From: [Haywood Planning Services](#)
To: [M54 to M6 Link Road](#)
Cc: [REDACTED]
Subject: M54/M6 Link Road Deadline 6 - 12 February 2021 Planning Inspectorate.
Date: 11 February 2021 15:07:16
Attachments: [Copy of Dark Lane data.xlsx](#)
[Copy of 6 months Dark Lane data.xlsx](#)
[Third set of written questions -response.docx](#)

I attach responses from South Staffordshire Council (SSC) to the Examining Inspectors third set of written questions for Deadline 6. Spreadsheets showing incidences of fly tipping in Dark Lane are also attached as requested in question 3.7.1.

Third set of written questions

Drawing Title
FIGURE 2.6
ENVIRONMENTAL MASTERPLAN
SHEET 4 OF 5
(REVISION 3)

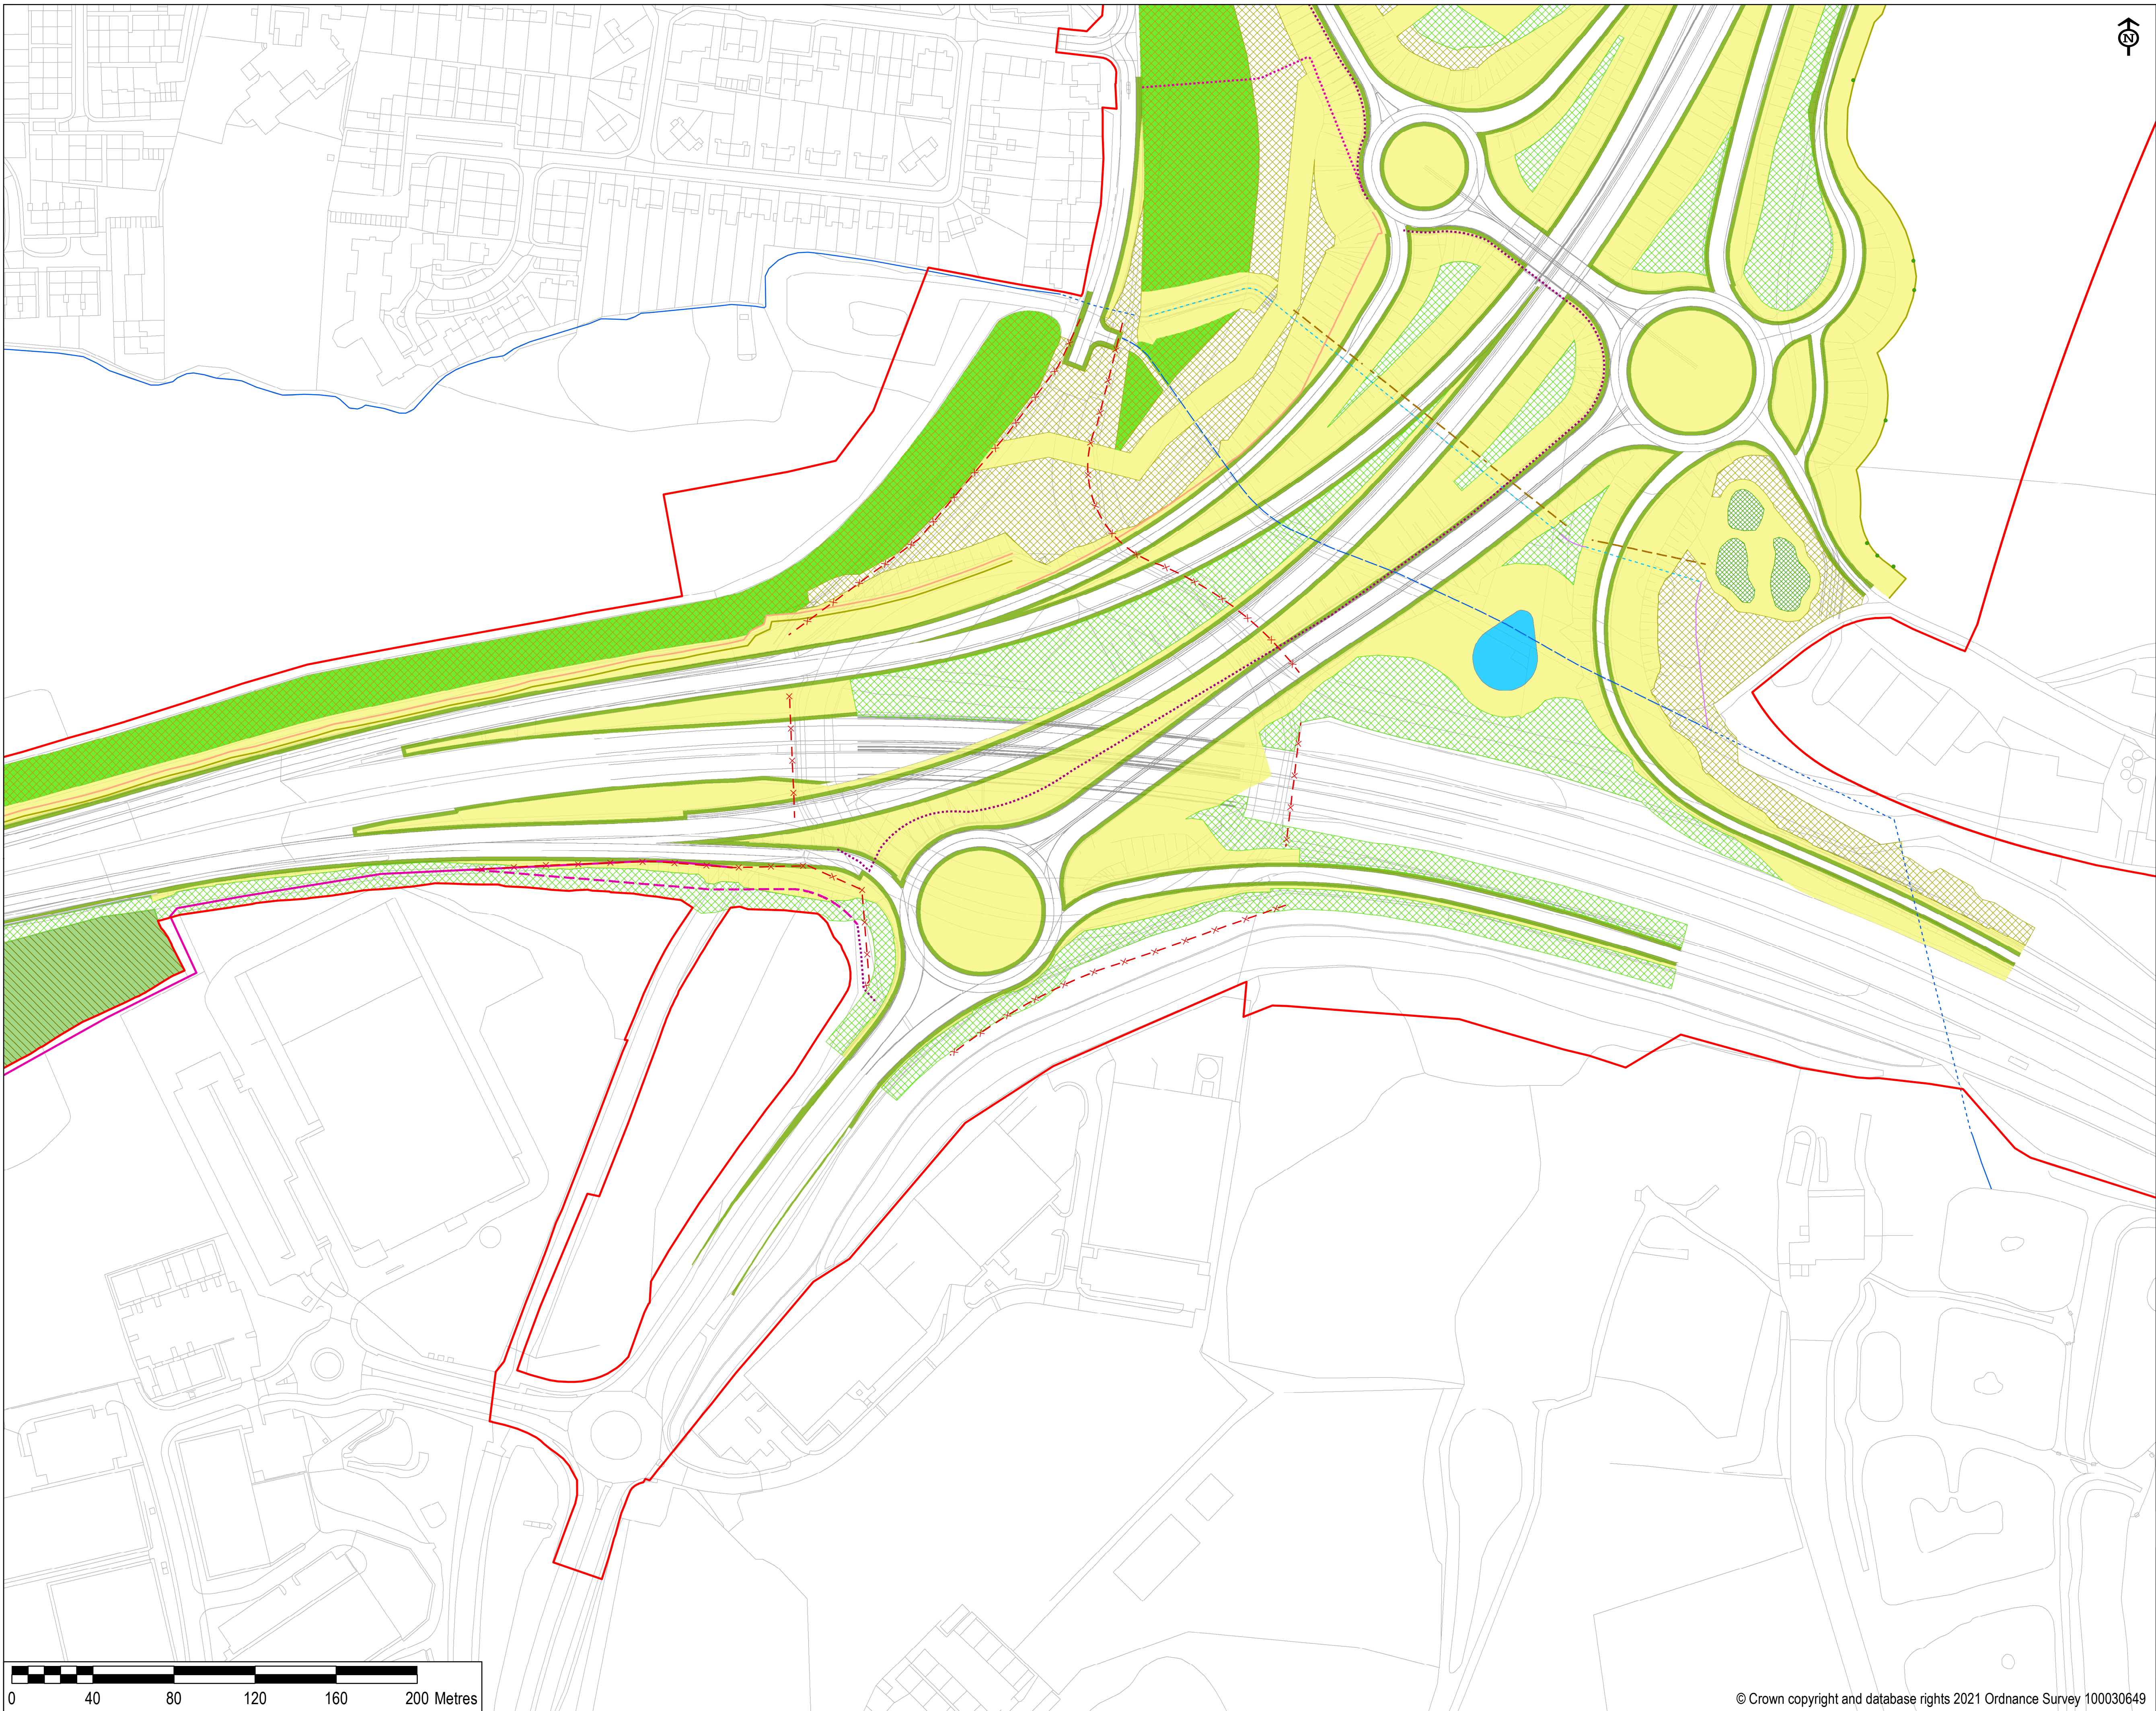
Allow Limited proposal is that mitigation planting should be located to the east of the proposal. Could the parties set out their positions as to the effects of this planting, were it to occur, on the special interest of the two veteran trees in this field (trees T-178 and T-182) as shown on Environmental Statement Figure 2.5 (Ver P15) [AS-090]?

SSC considers that the proposed landscaping is unlikely to affect the veteran trees. The location of the landscaping is at a distance that would not affect the trees through increased shading, changes in hydrology etc. The end use of the land assuming its agricultural, may have more of an effect, through live stock poaching and rubbing against the trees, or land preparation for crops with ploughing too close to these trees. SSC recommends that the veteran trees are fenced off in the long term to prevent damage from future land uses and a management plan secured for the management of the veteran trees.

Carefully designed planting could benefit the veteran trees by adding additional habitat and a degree of protection. It could be used to incorporate additional dead wood as log piles and could be designed as wood pasture, rather than dense woodland. Planting should allow for a halo space around each tree, preferably advised by an arboriculturalist with a Vet Tree certificate.

It is indicated that the existing Dark Lane fence is to be removed to be replaced by a hedgerow and fence. The fence being of similar height to that existing.

SSC consider that the new fence should be erected behind a new native hedgerow to ensure that this feature respects the character and appearance of the countryside and represents a design enhancement over the existing fence. It is also noted that this approach may not be possible to the east of the last property along Dark Lane due to restricted space in this area. SSC considers that alternative options should be considered here i.e. could a hedgerow be planted directly behind this section of fence which grows through the fence to soften its impact or additional planting added between existing trees?
